Response to Planning Application

Application ref: EP/62/20/DOC

Description: Approval of details reserved by condition imposed under ref EP/179/18/PL relating to Condition Nos 3 - water drainage, 4 - visibility splays, 5 - car parking & turning arrangements, 6 - covered & secure cycle parking, 7 - finishes, 8- hard & soft landscaping and 10 - existing wall to south

Location: Gladwyn The Street East Preston BN16 1HT

Scales: 1:50 1:200
No: 2386/01/12

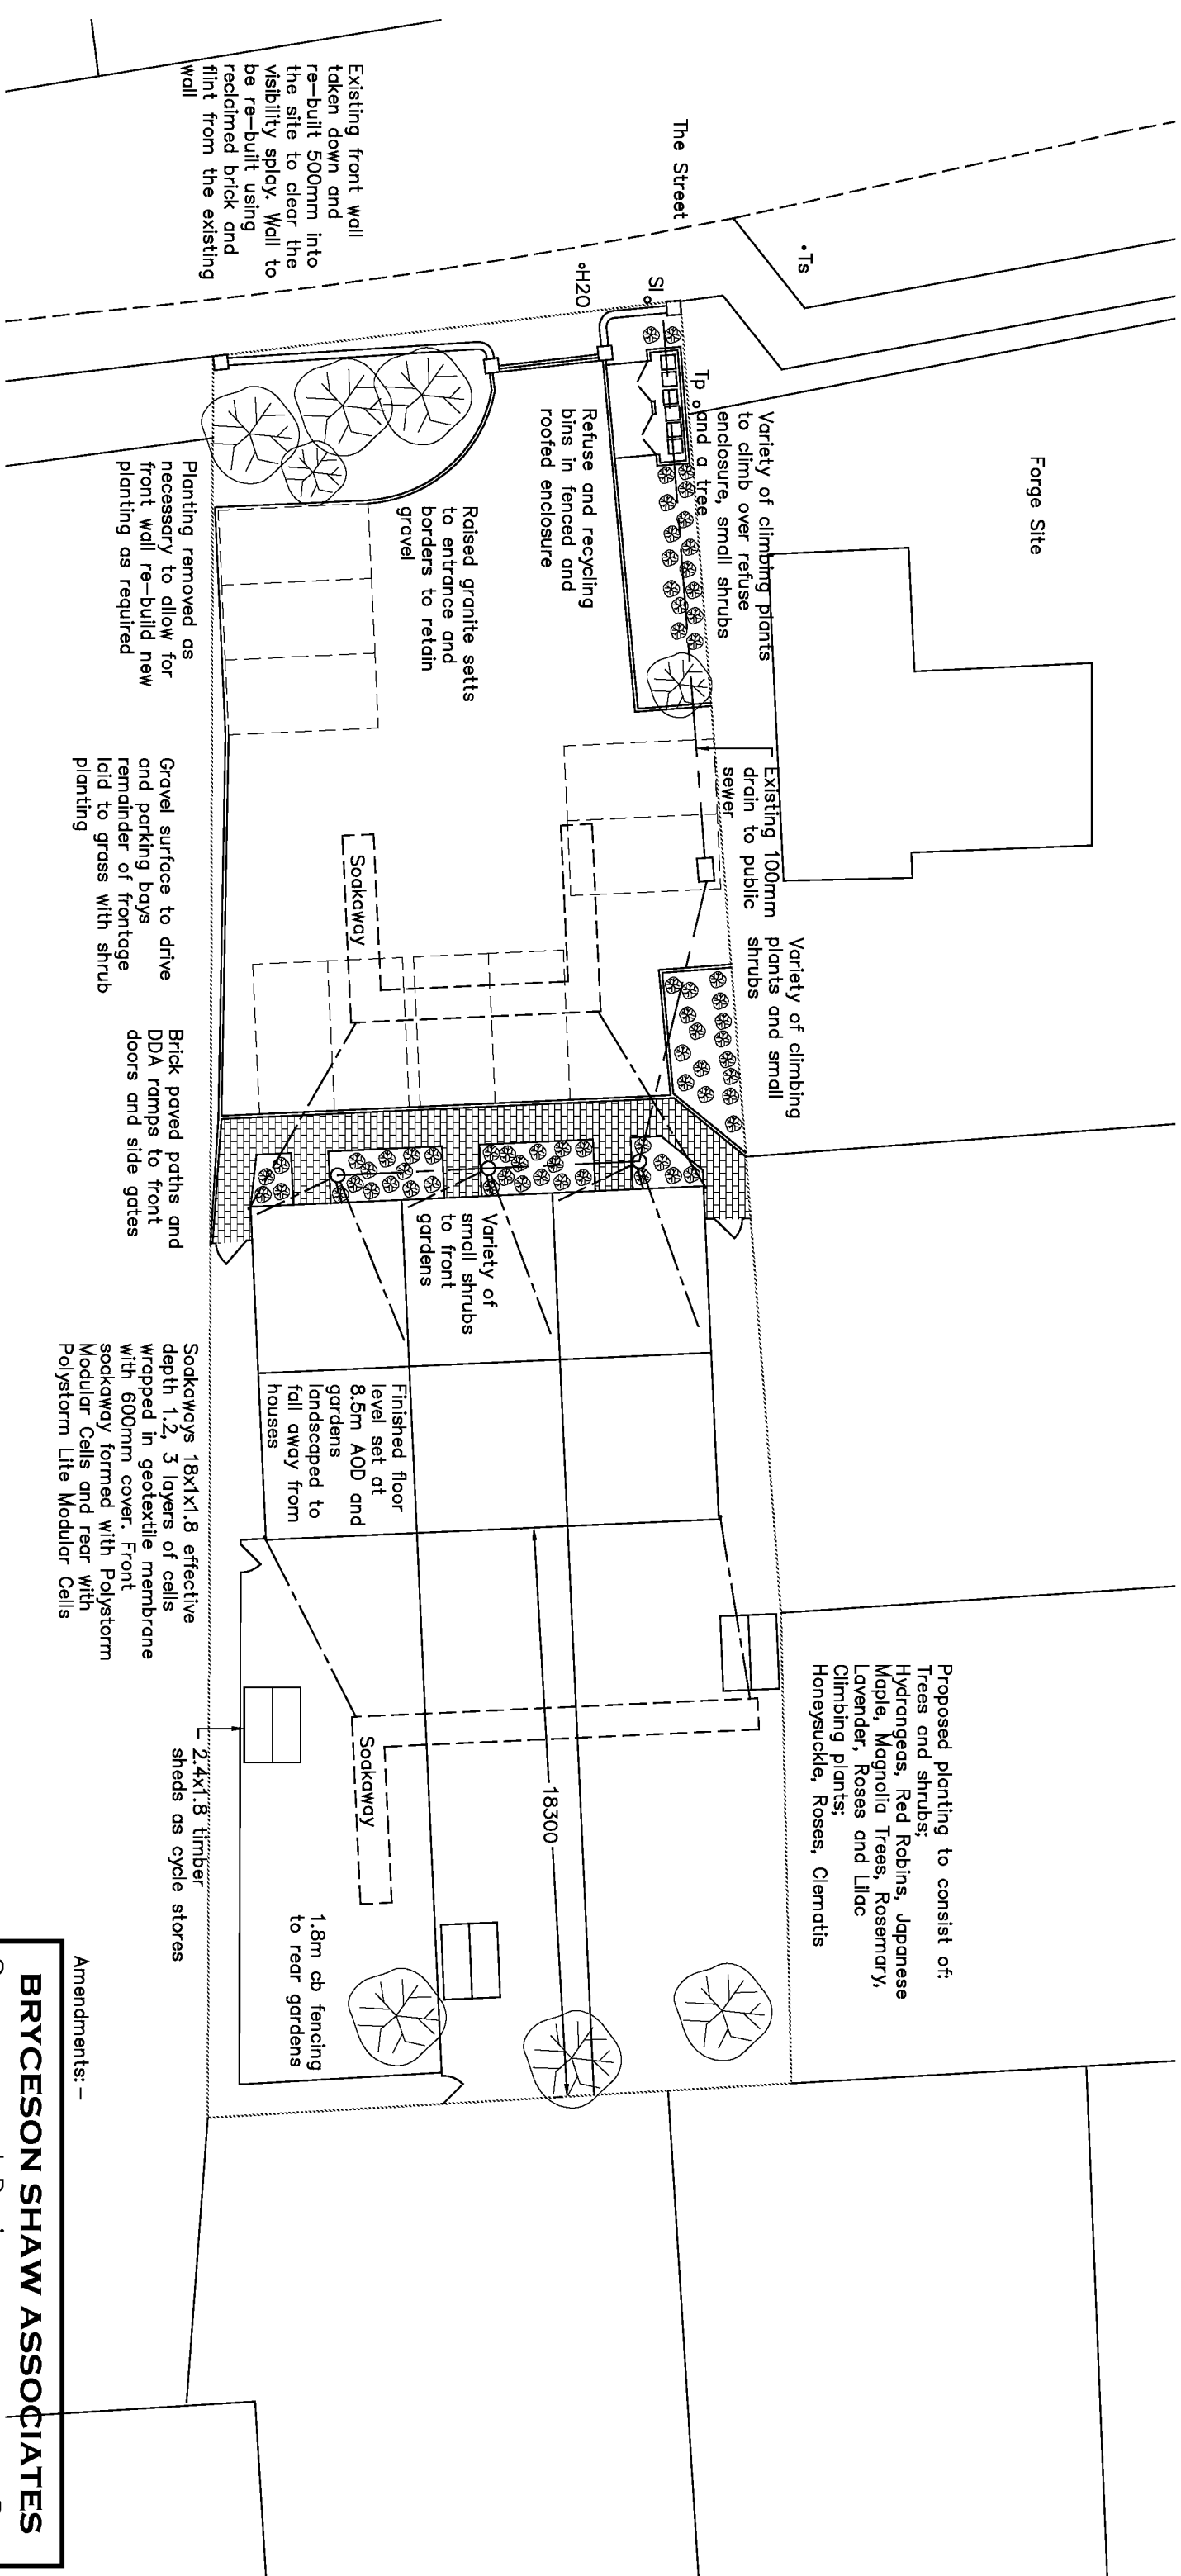
Following submission of Dwg Landscape and external works 2386/01/12 May 2020 plus plant schedule, I can confirm that this does contain a suitable landscape scheme with sufficient plant detail including species type, quantities and size at time of planting.

I would therefore **recommend the discharge of Condition 8** hard and soft landscaping on this application EP/62/20/DOC imposed under EP/179/18/PL.
